CITY OF ALBUQUERQUE

Re: Neumark Irrigation Supplies Building Addition, 811 Rankin Road NE, Grading and Drainage Plan

Engineer's Stamp dated 12-15-04 (G15-D63)

GRADING AND DRAINAGE PLAN

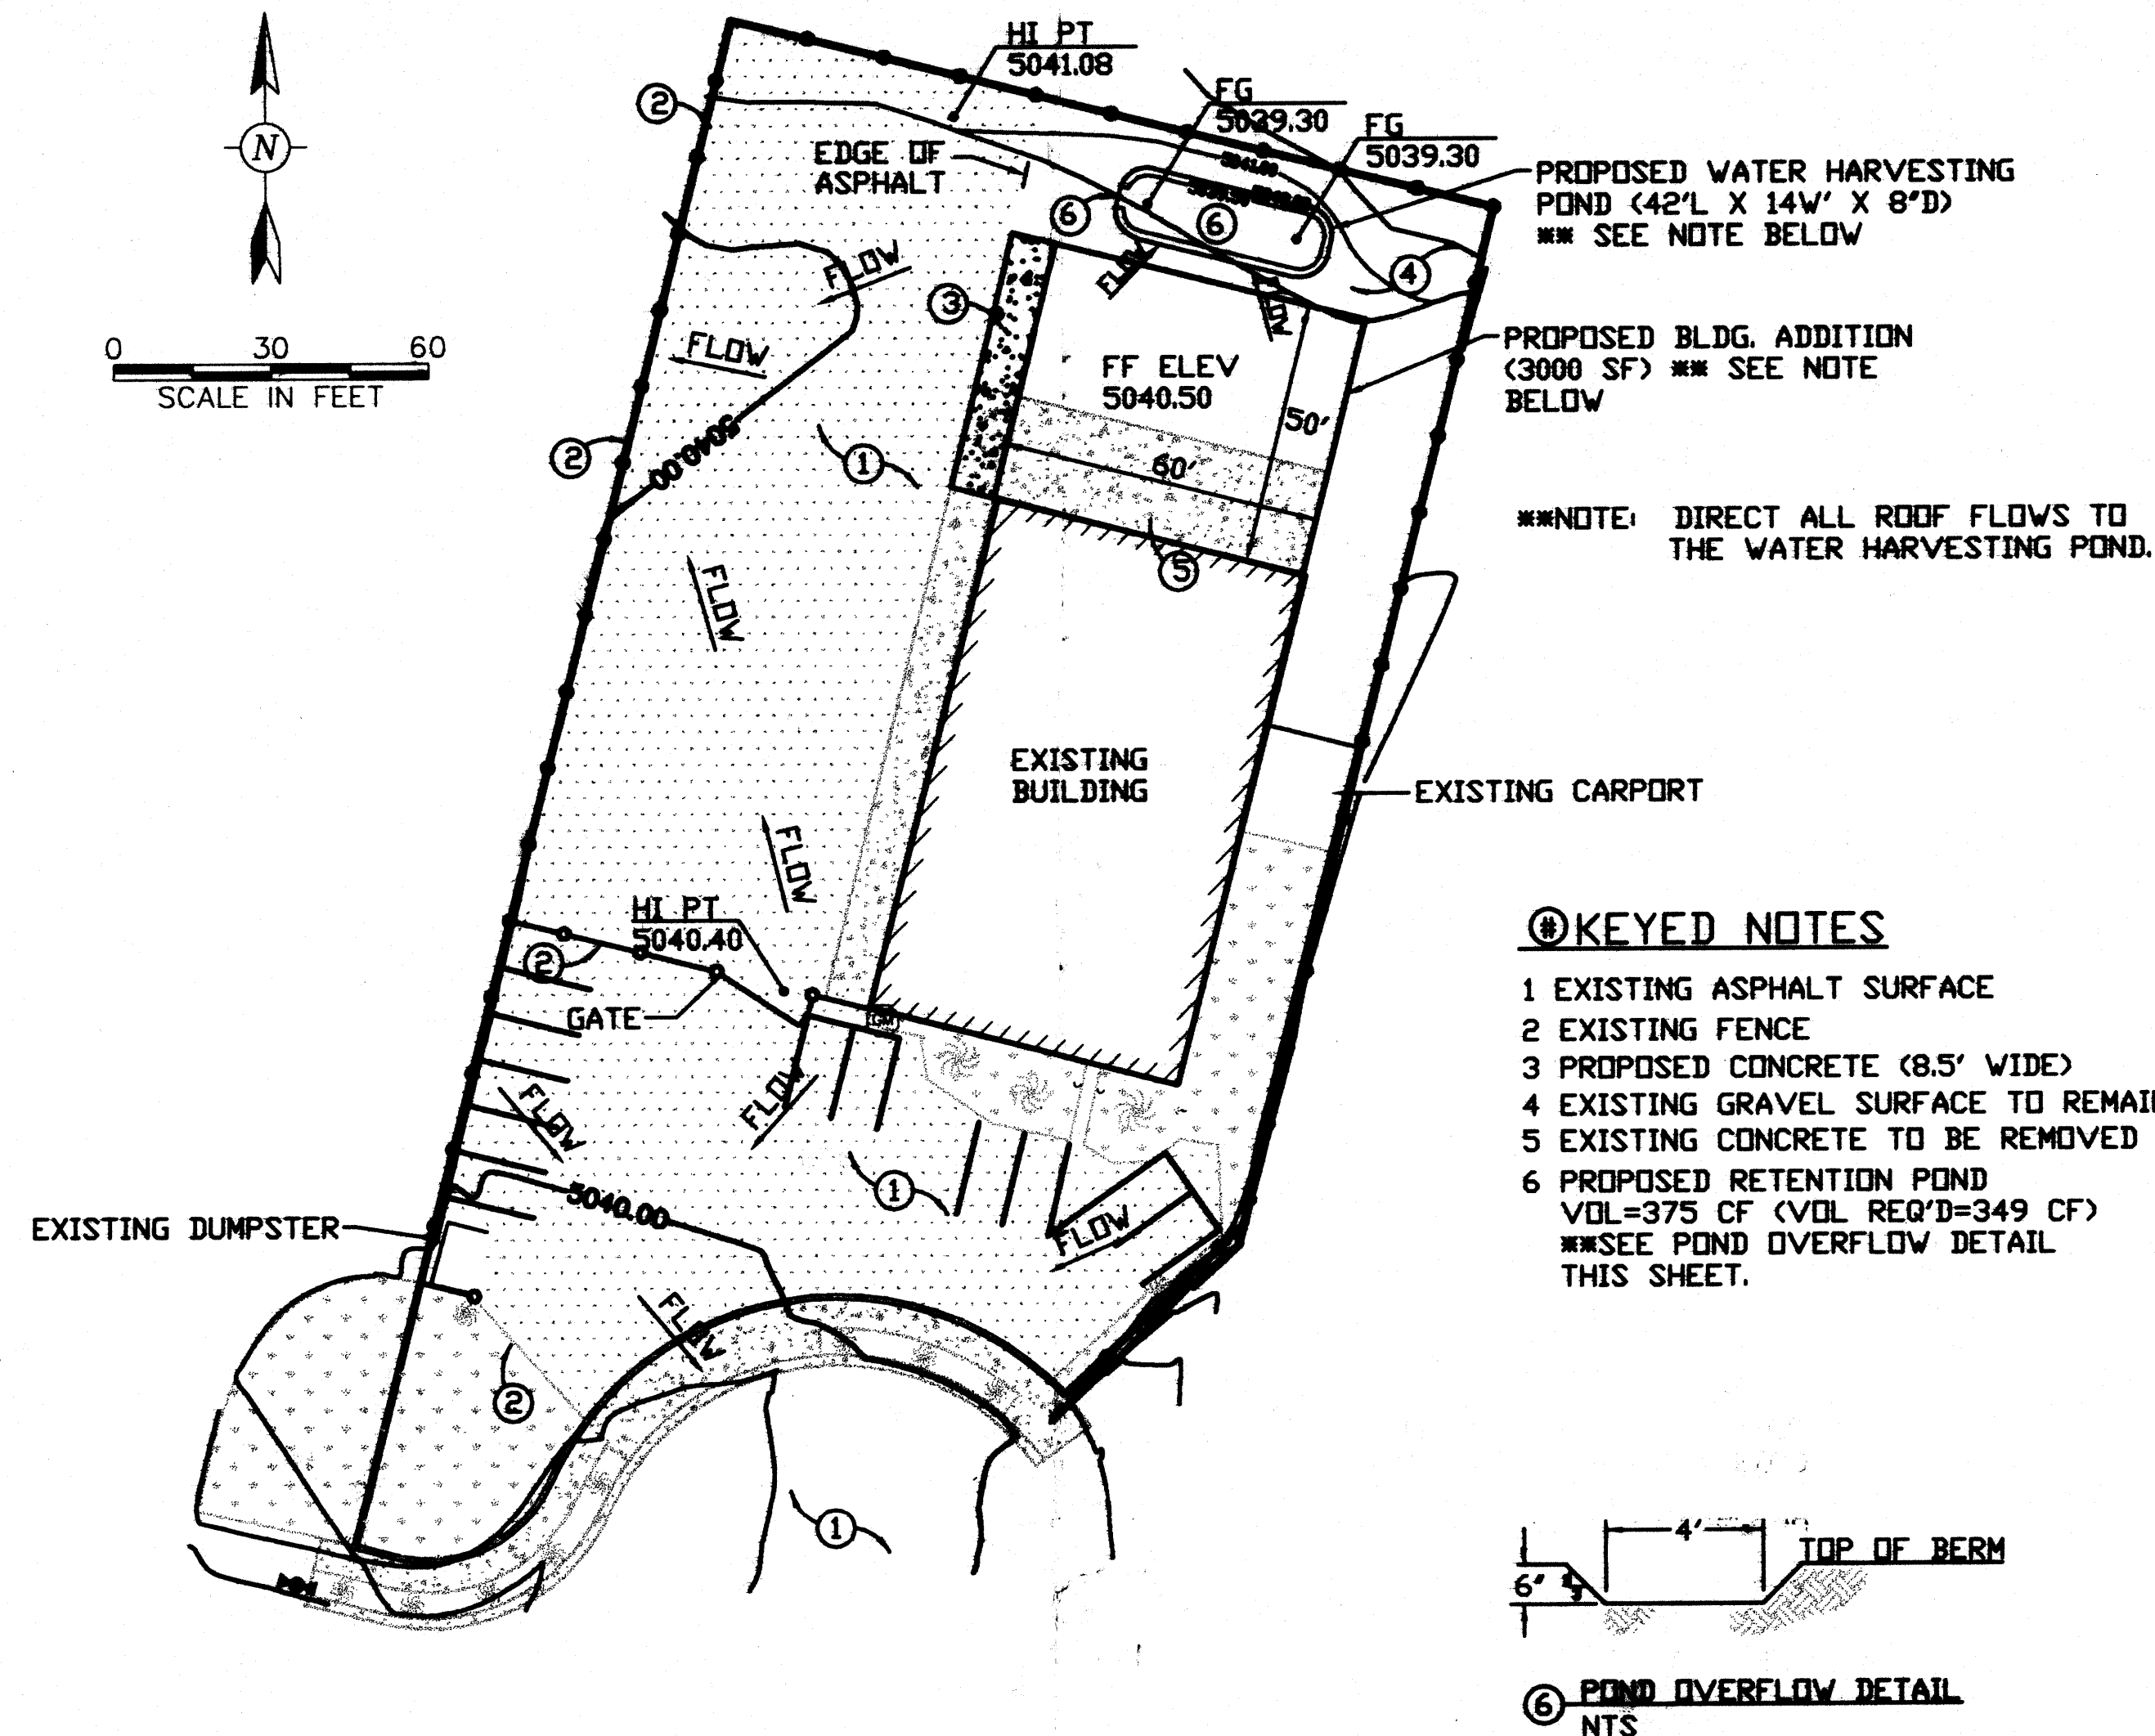
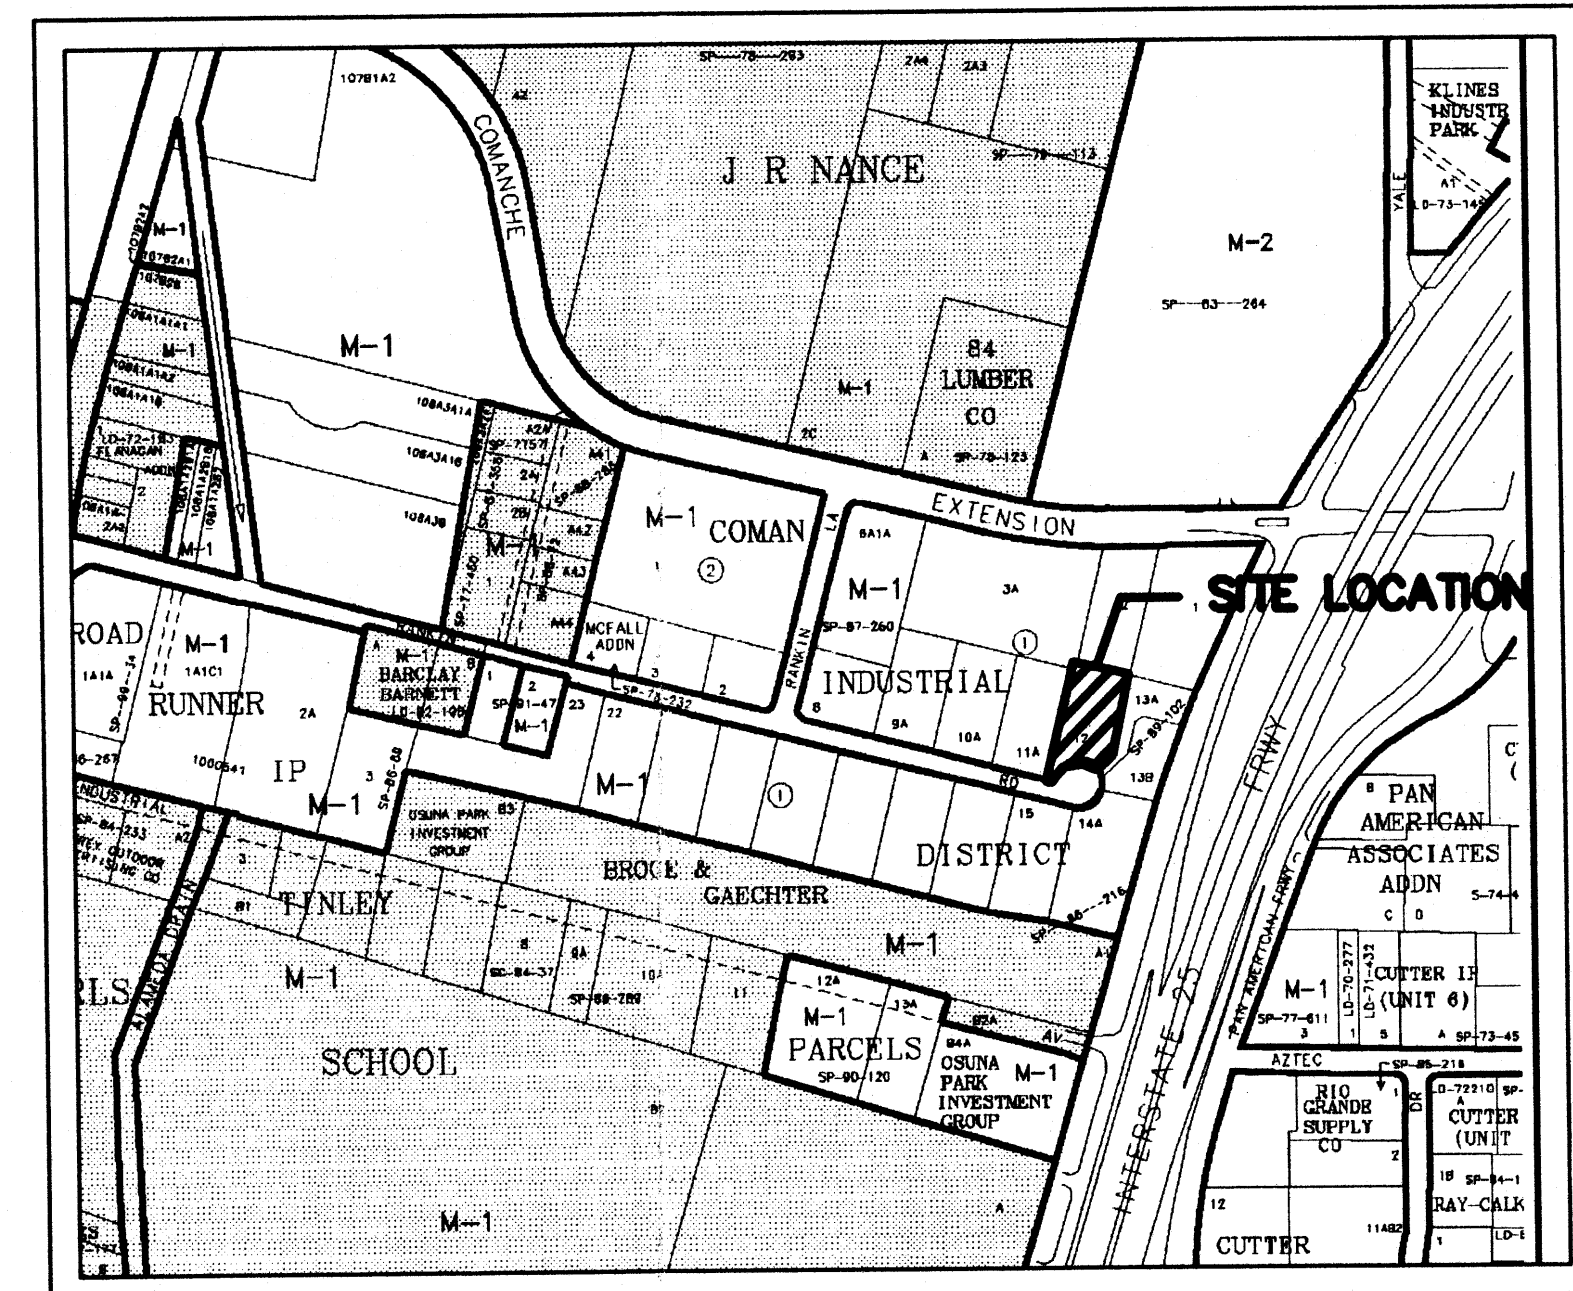
Check this plan: should have a water harvesting pond and a pond overflow detail

Based upon the information provided in your submittal received 12-15-04, the above referenced plan cannot be approved for Building Permit until the following comments are addressed:

- 1. Direct all roof flows to the water harvesting pond.
- 2. Show which areas are paved and which are not.
- Albuquerque
- 3. Provide an overflow structure for the pond.
- 4. Show a detail of the pond overflow structure.
